14 August 2025

**Re: Objection to State Significant Development Application SSD-82899468
Concept Proposal for a Residential Flat Building with In-fill Affordable Housing at
1–5 Nelson Road, Lindfield**

Figure 38 Shadow diagrams for June 21 from 9am to 3pm.

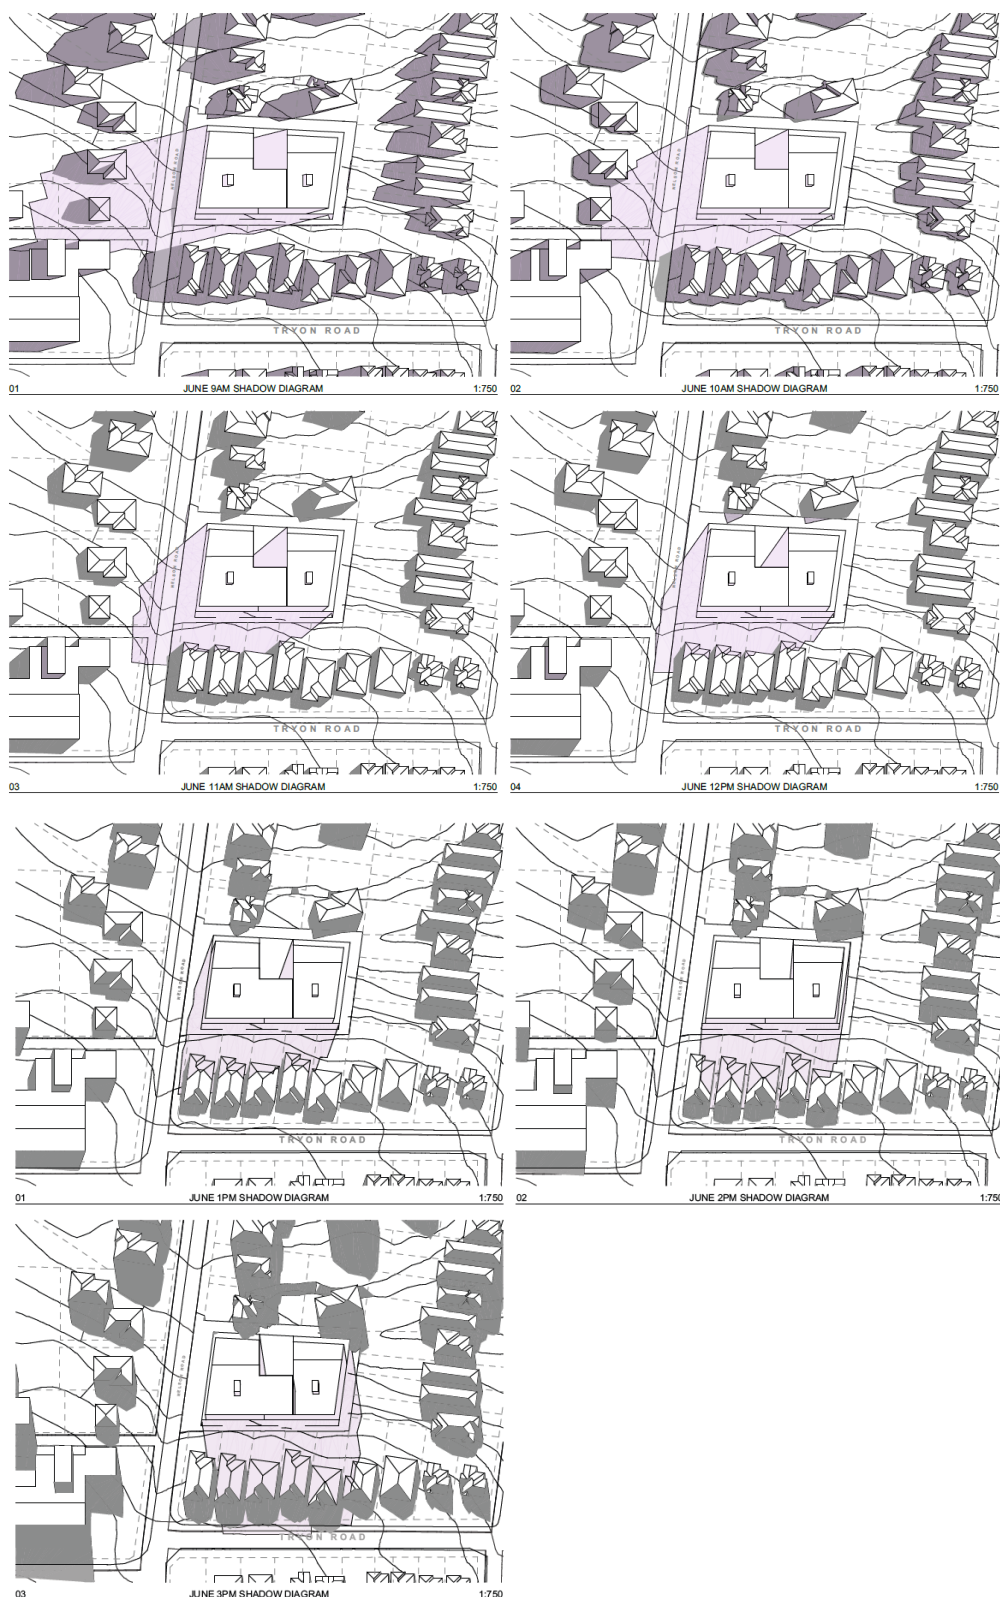
- Shadow diagrams indicate significant overshadowing of Nelson Rd, Tryon Rd, and Cromehurst School playground.
- Privacy impacts likely for Lightcliff Ave properties; no screening measures are proposed.
